21 Dec 2021

**SSD-16858710 Pacific Brook Christian School – Muswellbrook Shire Council
Request for Comment**

Sharon Pope
EXECUTIVE MANAGER ENVIRONMENT AND PLANNING

OSD DISCHARGE CONTROL PIT DETAILS
SCALE 1:10

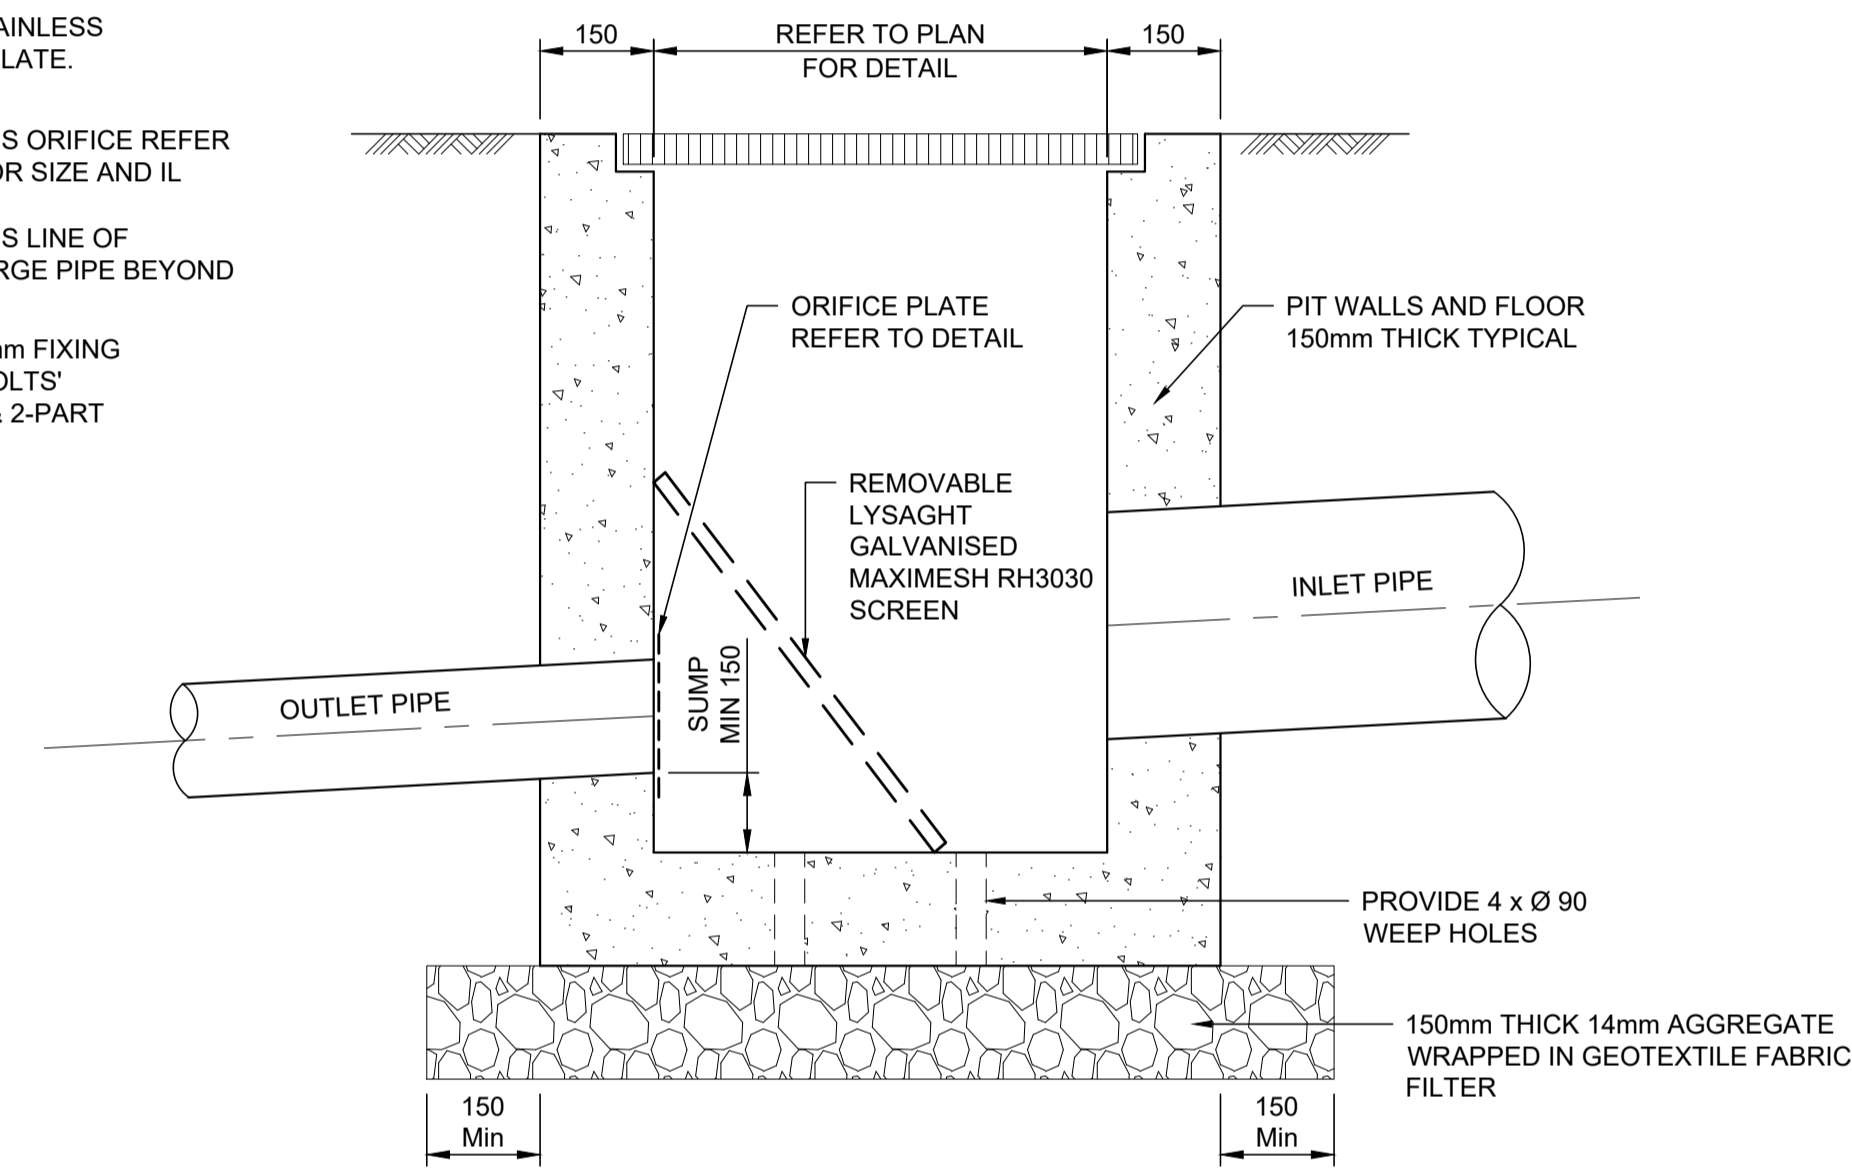
4. **Stormwater** – The following observations are made on the stormwater information provided:
 - The On-Site Detention requirements for the school are inconsistent within the report and between the report and the engineering plans. The correct OSD requirements should be detailed clearly in all references to the OSD system for the site in accordance with MSC DCP and control discharge to pre-development levels. Any OSD system should be designed to be load rated for both the expected construction and in-service loads including maintenance vehicles. Prior to CC, a maintenance manual should accompany all stormwater treatment and detention systems. It is recommended that below-ground stormwater detention requirements can be further reduced by providing rainwater tank facilities on the site with additional detention volume as part of the overall site OSD.

STORMWATER AND EXTERNAL WORKS - SHEET 01

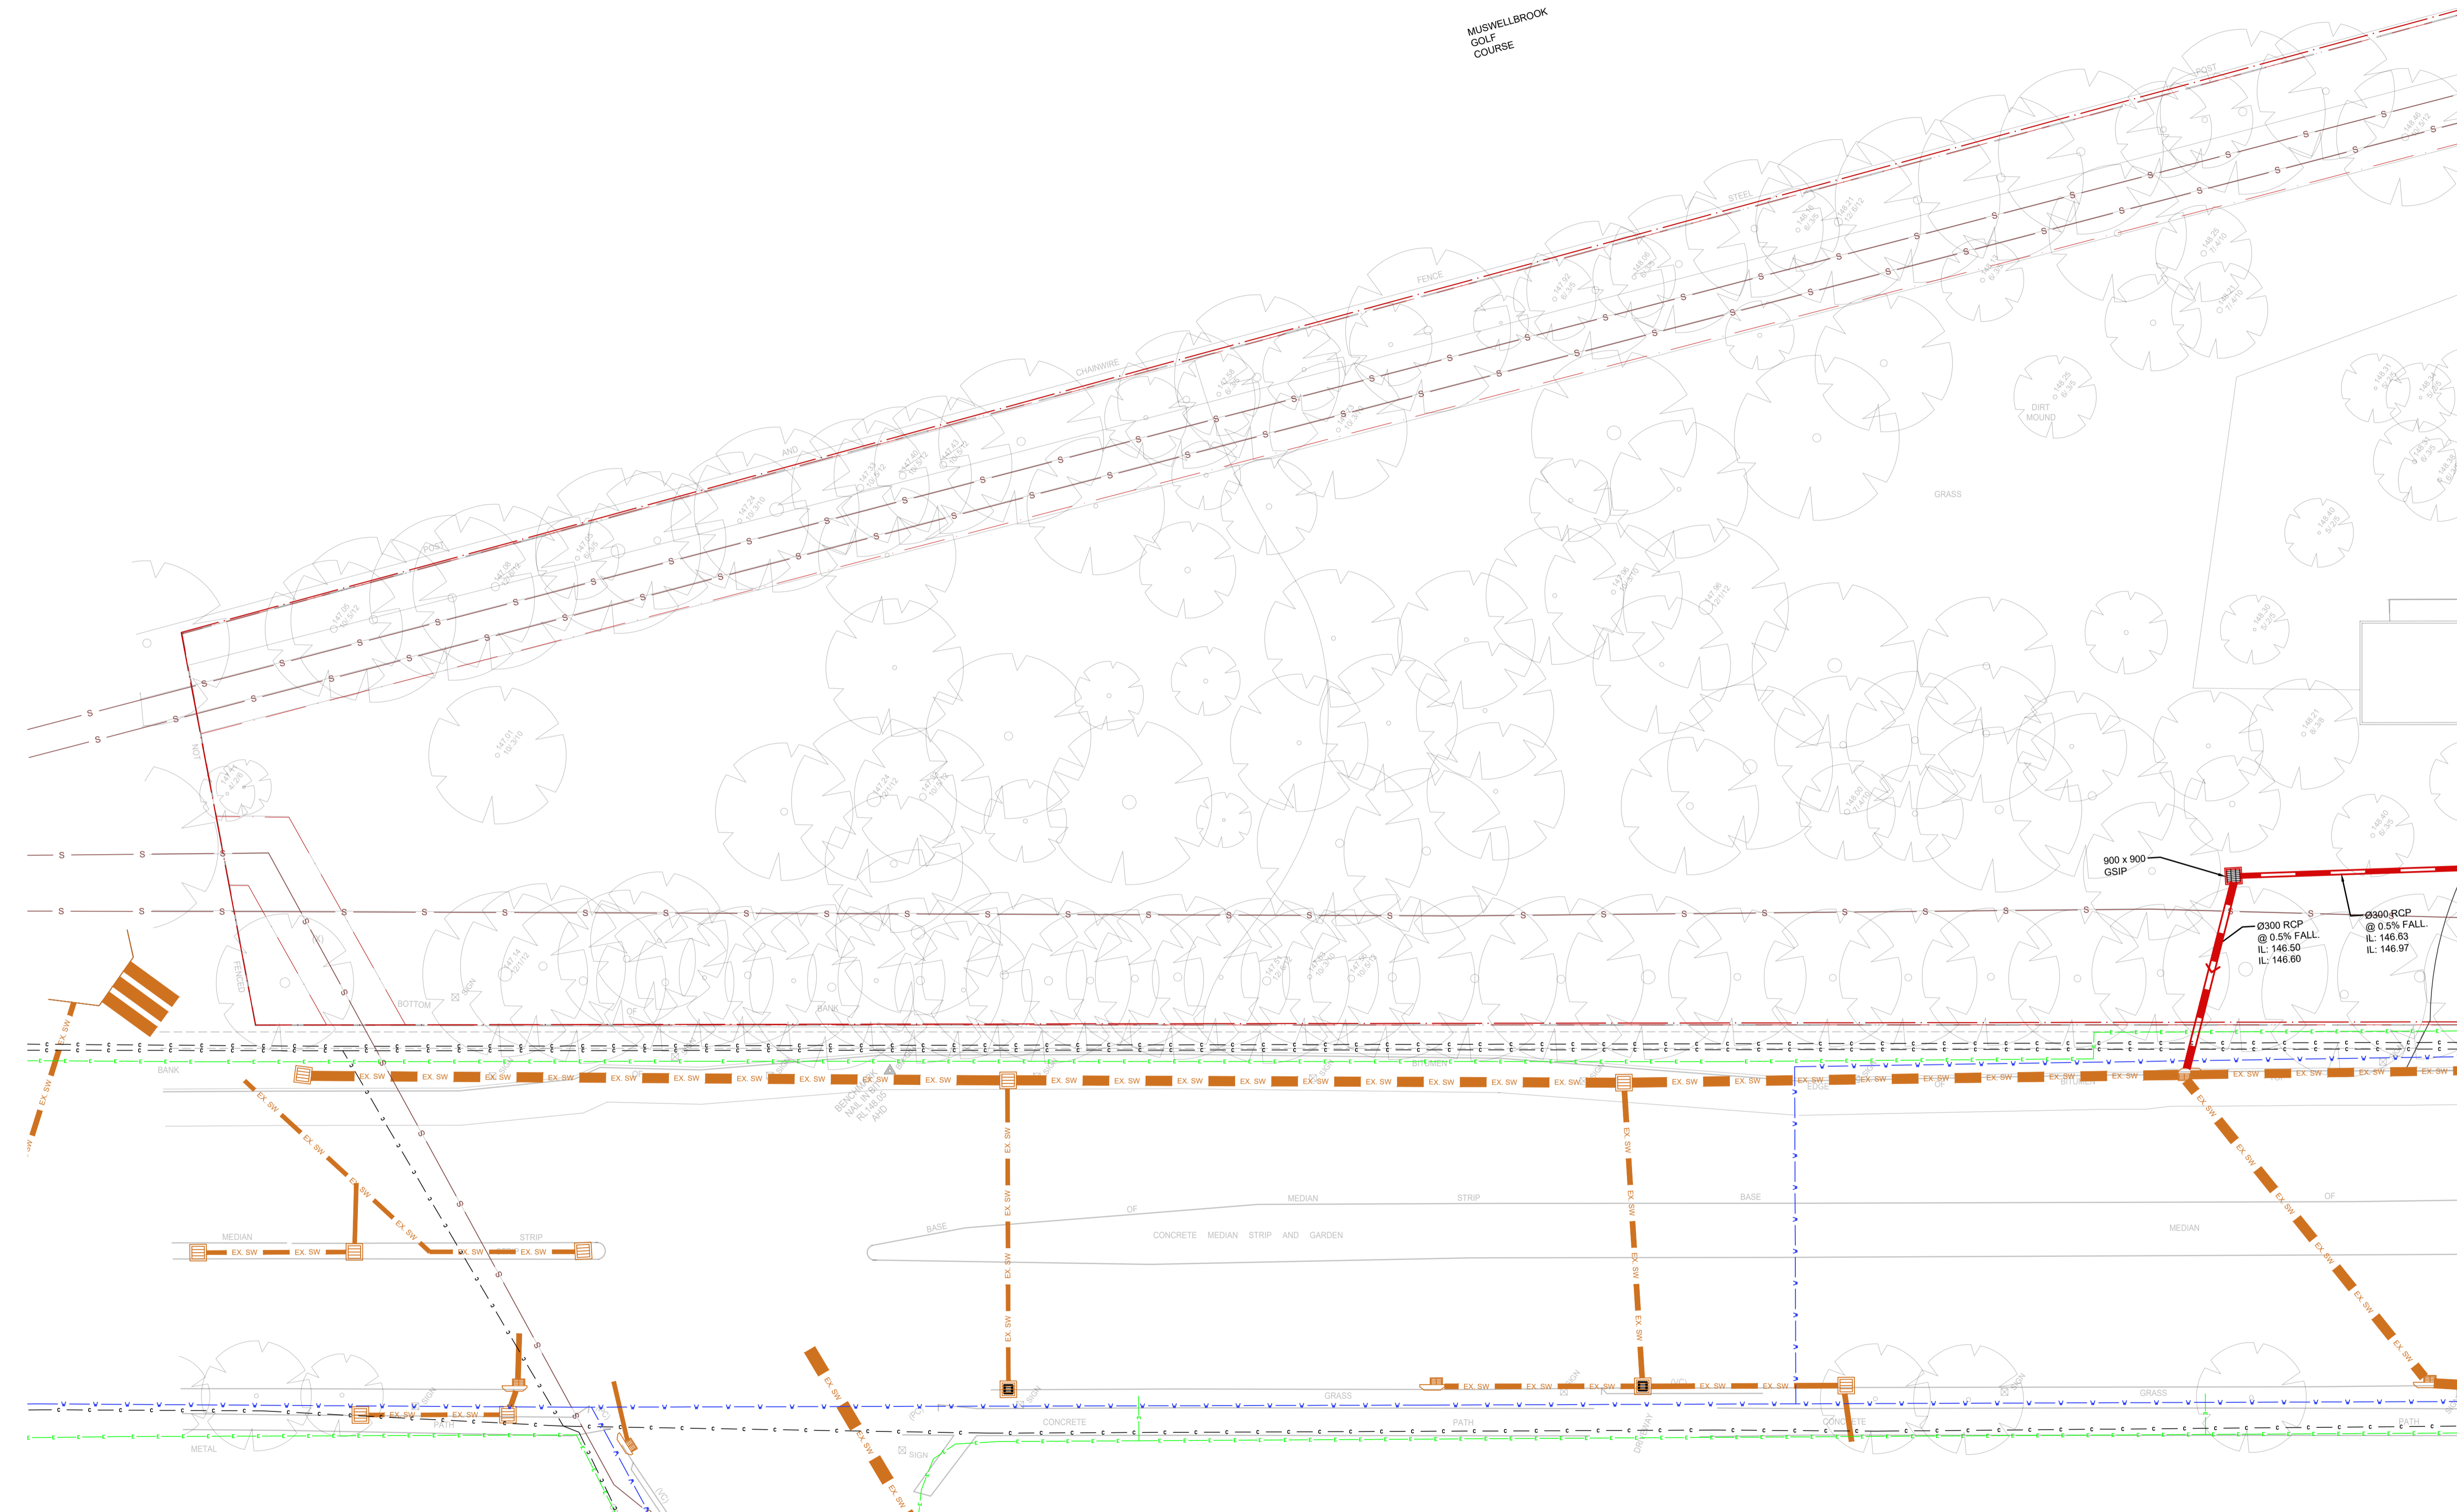
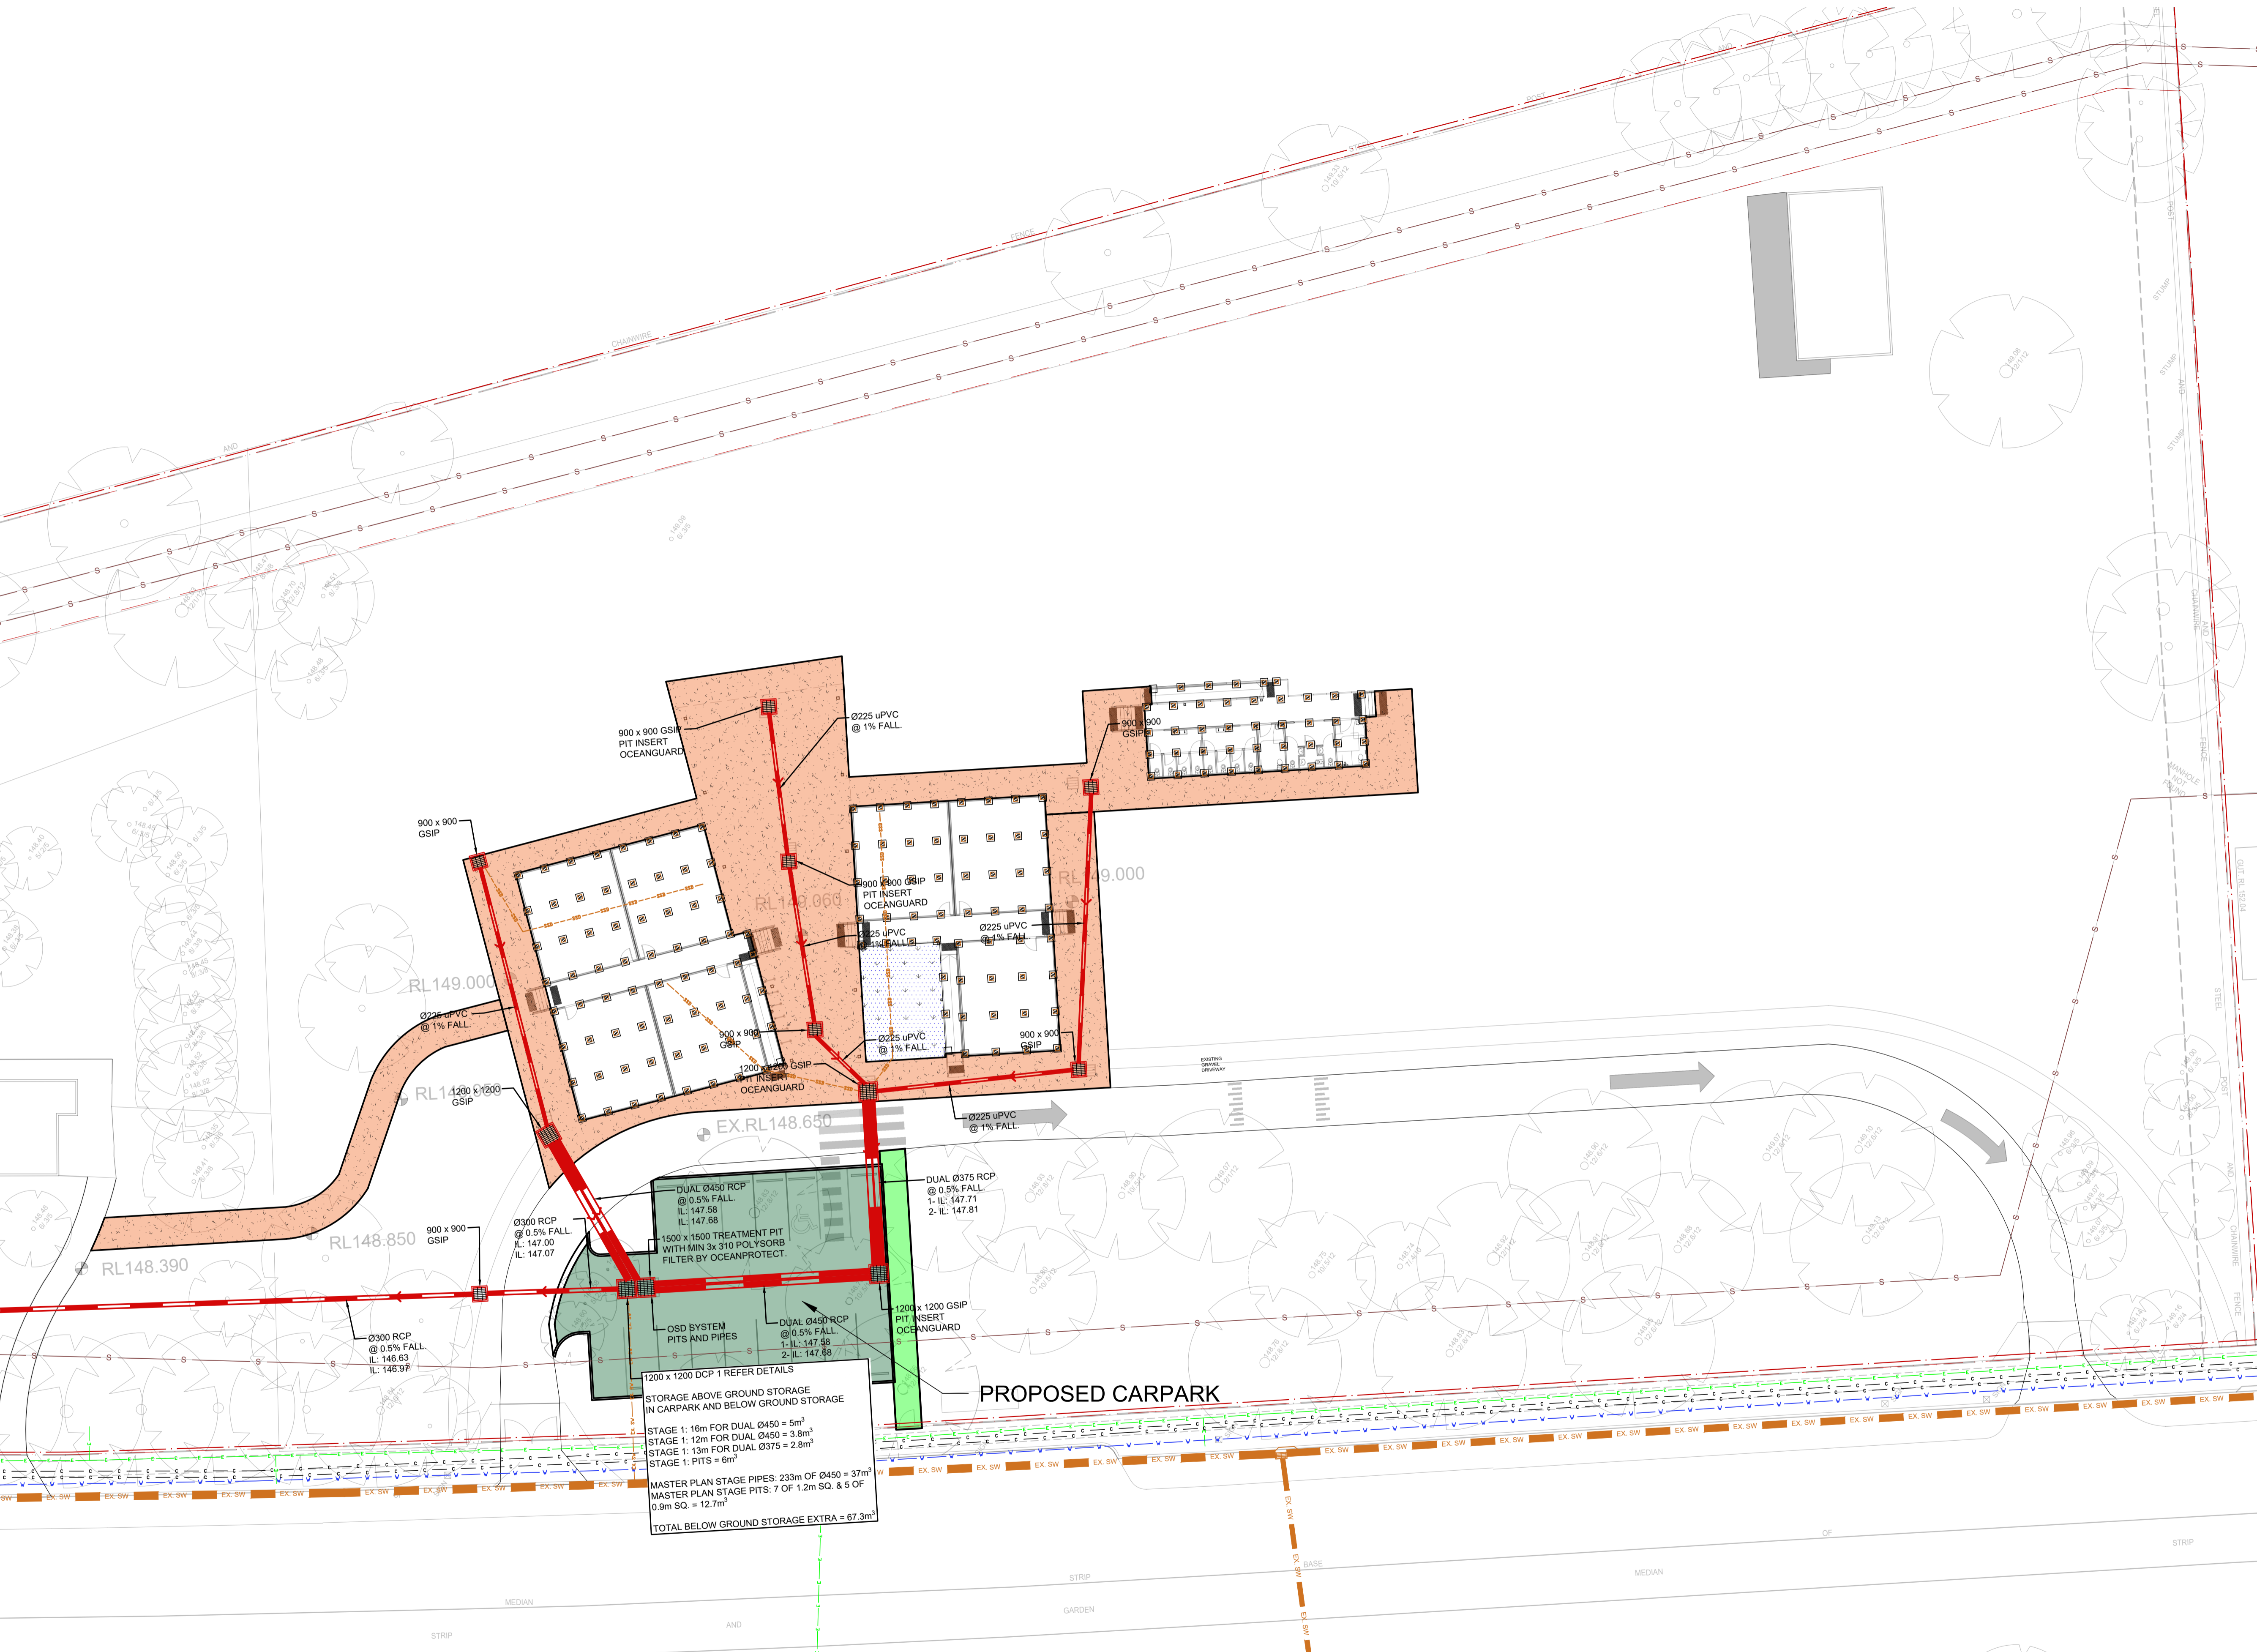
- Above-ground detention depth is not shown for the car park but should be less than 200mm in depth
 - Prior to CC, all details of the drainage lines should be detailed including invert and finished service levels and accompanied by a compliant DRAINS and MUSIC model for validation of the design
